REQUEST

Current Zoning: N1-A (Neighborhood 1-A) and IC-1 (Institutional Campus-1)
Proposed Zoning: N2-A(CD) (Neighborhood 2-A, Conditional)

Approximately 23.42 acres located along the east side of South Tryon Street and west side of Steele Creek Road, north of Hamilton Road.

The petition proposes to develop a vacant, wooded property in the Steele Creek community with up to 187 multi-family attached dwellings along with accessory uses permitted in the N2-A(CD) zoning district.

DRAWING NO.: **RZ-01**

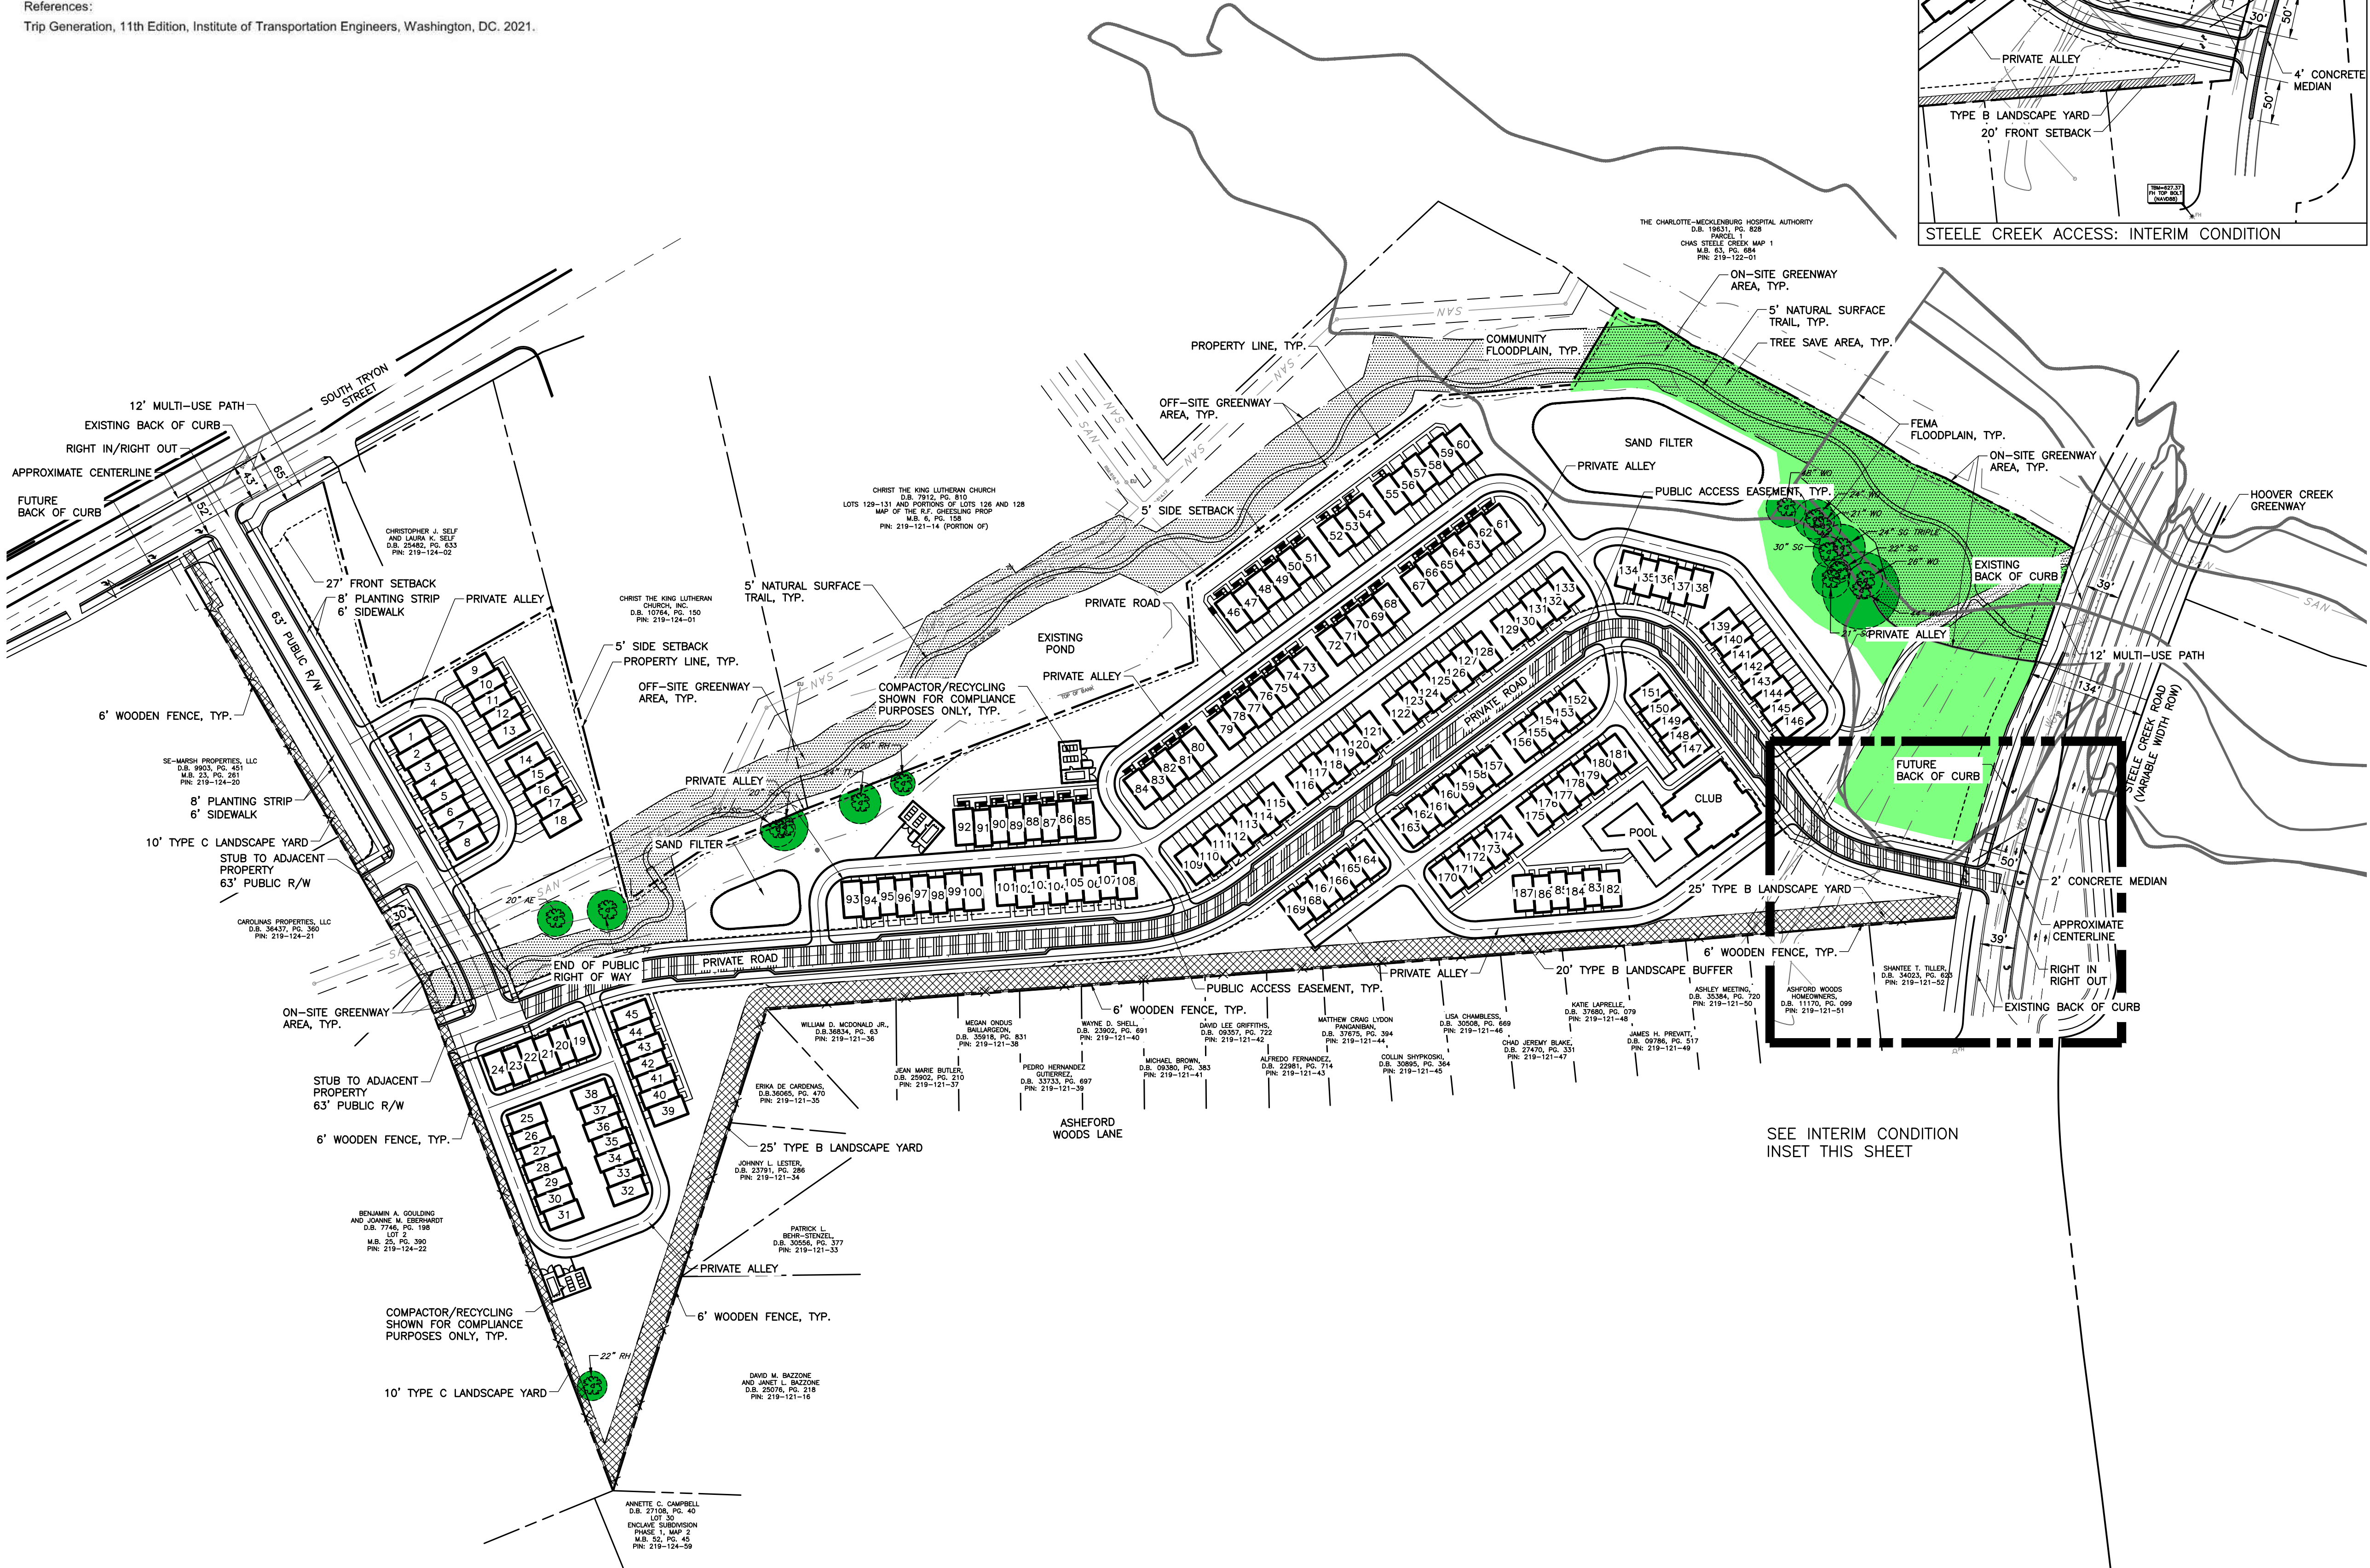
- ~~1. Provide a tree survey showing all city trees 8" DBH or greater and all planted city trees, all existing heritage trees on site, and any existing areas of the site used for credit toward meeting previously approved tree save or green area requirements. —~~ **Addressed**
- ~~2. Revise site plan to show that tree save areas are contiguous and a minimum of 30' wide. —~~ **Addressed**

- ~~3. Revise site plan to show interim condition on Steele Creek Road and screen in the final condition to be installed by NCDOT as part of the Steele Creek Widening Project. Callout concrete median on Steele Creek Road on the inset. Label and dimension the median length. Median should be shown to extend to 50' past radius returns at the new street connection. —~~ **Addressed**
